Application No: AW/353/20/OUT
Site Address: Land adjacent to 1 Cambridge Walk Aldwick PO21 5RL
Description of works: Outline application with some matters reserved for 1 No. new dwelling.

Thank you for your internet representation made on 28th February 2021 which has been recorded as an objection with the comments as follows:

1, Cambridge Walk, Aldwick, West Sussex, PO21 5RL

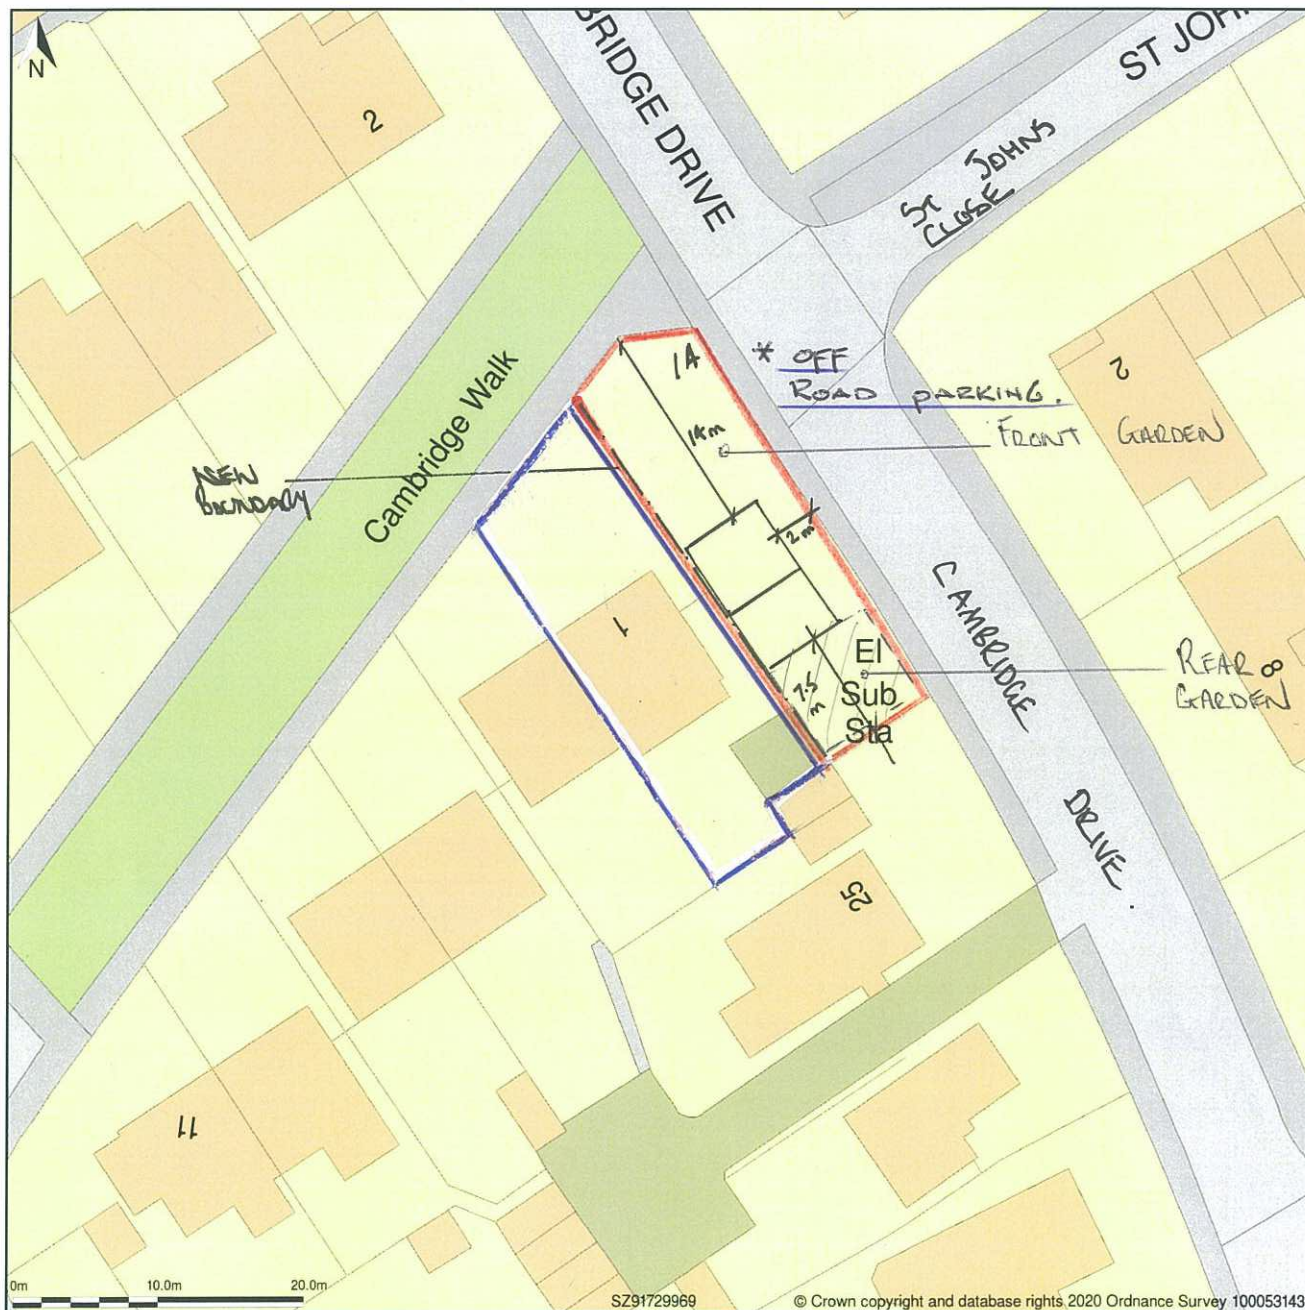
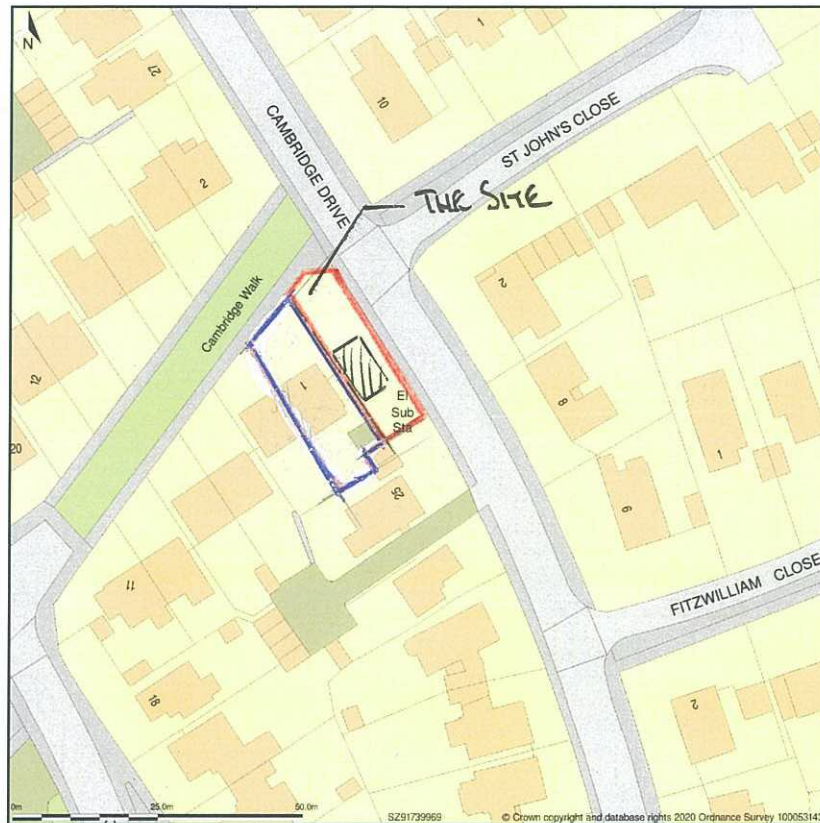
Access to the SSE Electricity Sub-Station - if the Sub-Station fails the affected properties could be severely inconvenienced whilst access to the Sub-Station is provided. I understand a Right of Way (or similar) is in place with SSE but should the whole area be 'Fenced Off' as stated as part of the creation of the rear garden, and / or additional Car Parking Space provided here (should this be required) I am extremely concerned that a delay will occur before any rectification work by SSE could start.

6 Foot Fencing is proposed in the application which goes against 'The Openness' requirements.

The Out Line Application makes specific reference to there being NO requirement for "new or altered vehicle access to or from the public highway". Whilst on the details for the Out Line Plans it clearly shows a preferred requirement for off road parking in the front garden which would require access from the Highway. There is however an alternative proposed for rear parking for which there is the Sub Station access concern.

3 of the smaller trees would require removal as they are currently located on the proposed foundation line, whilst the roots of the mature Silver Birch tree are likely to be affected by the Construction of the Foundations potentially requiring removal of the tree.
